CITY OF ALBUQUERQUE

February 22, 2023

Re: Raising Cane's
99999 Gibson Blvd. SE
Traffic Circulation Layout
Engineer's Stamp 02-10-23 (L15-D051A)

Based upon the information provided in your submittal received 02-13-23, the above referenced plan cannot be approved for Building Permit until the following comments are addressed:

C5.0

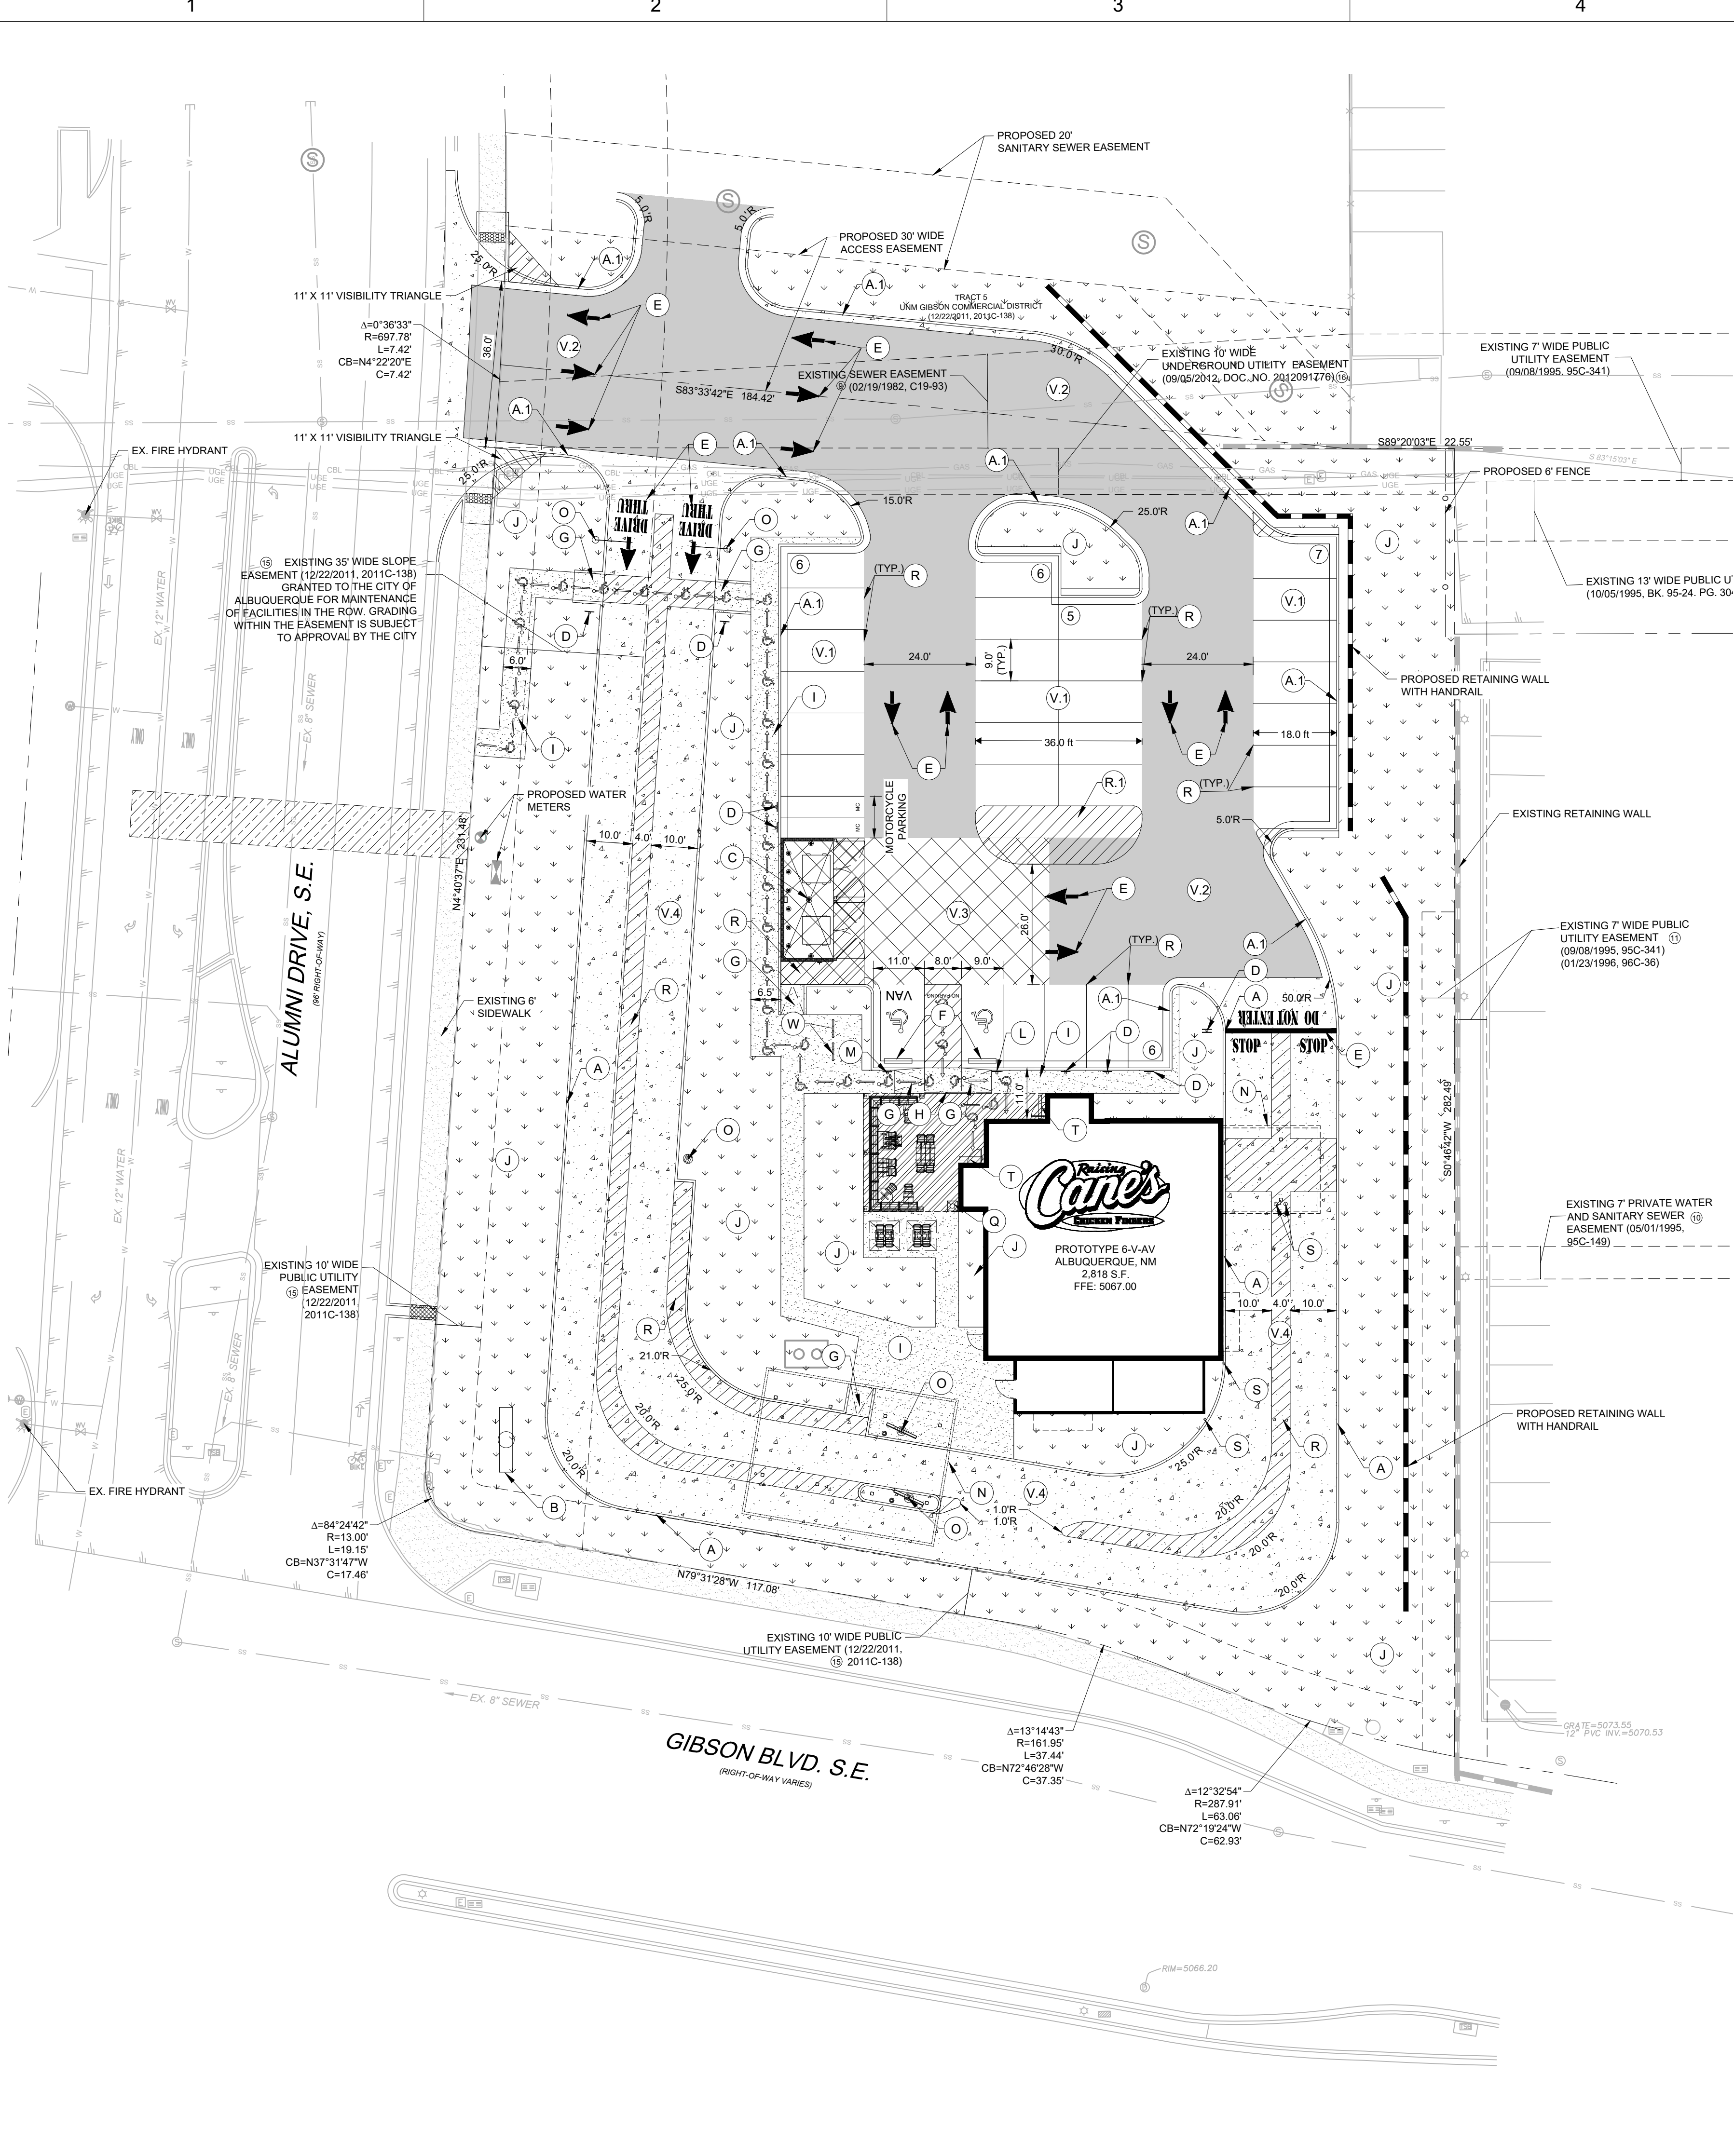
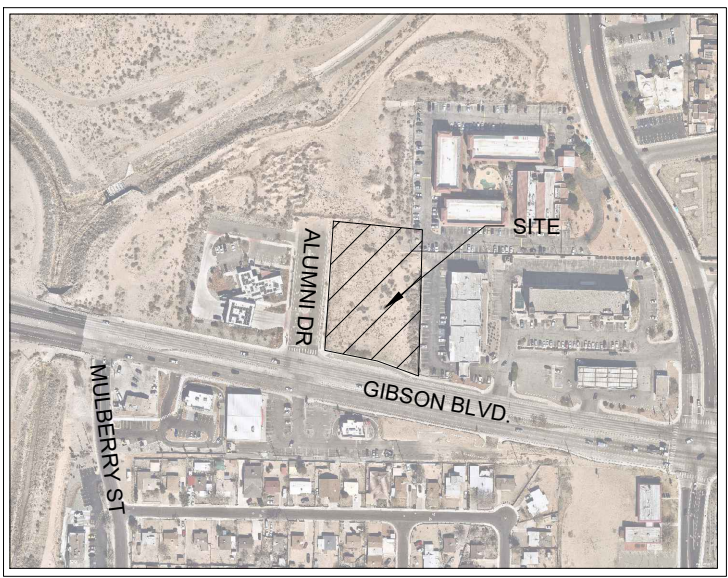
1. Please provide Easement agreement for the proposed 30' wide access easement.
2. Provide details for the ADA ramps at the driveway access off Alumni Dr. SE.

3. Provide details for all the proposed Bike Rack, signs, and pavement marking. Sheet C5-2 is missing.
4. The ADA accessible parking sign must have the required language per 66-7-352.4C NMSA 1978 **"Violators Are Subject to a Fine and/or Towing."** Please call out detail and location of signs.

5. A 25-foot minimum radius for all turns, must be provided for the drive-thru lanes inside edge.
6. Please clarify, are you proposing a pathway connection from the west side public sidewalk across Alumni Dr. SE.?

7. Provide dimensions for the parking spaces at the north side of the Trash Dumpster.
8. Provide Intersection sight distance Triangle at the intersection of Gibson Blvd. and Alumni Dr. See attached table 3.9.5-2

9. Please add the following note to the plan: "Landscaping and signage will not interfere with clear sight requirements. Therefore, signs, walls, trees, and shrubbery between 3 and 8 feet tall (as measured from the gutter pan) will not be acceptable in the clear sight triangle.

10. Add a note stating "All broken or cracked sidewalk must be replaced with sidewalk and curb & gutter." A build note must be provided referring to the appropriate City Standard drawing.
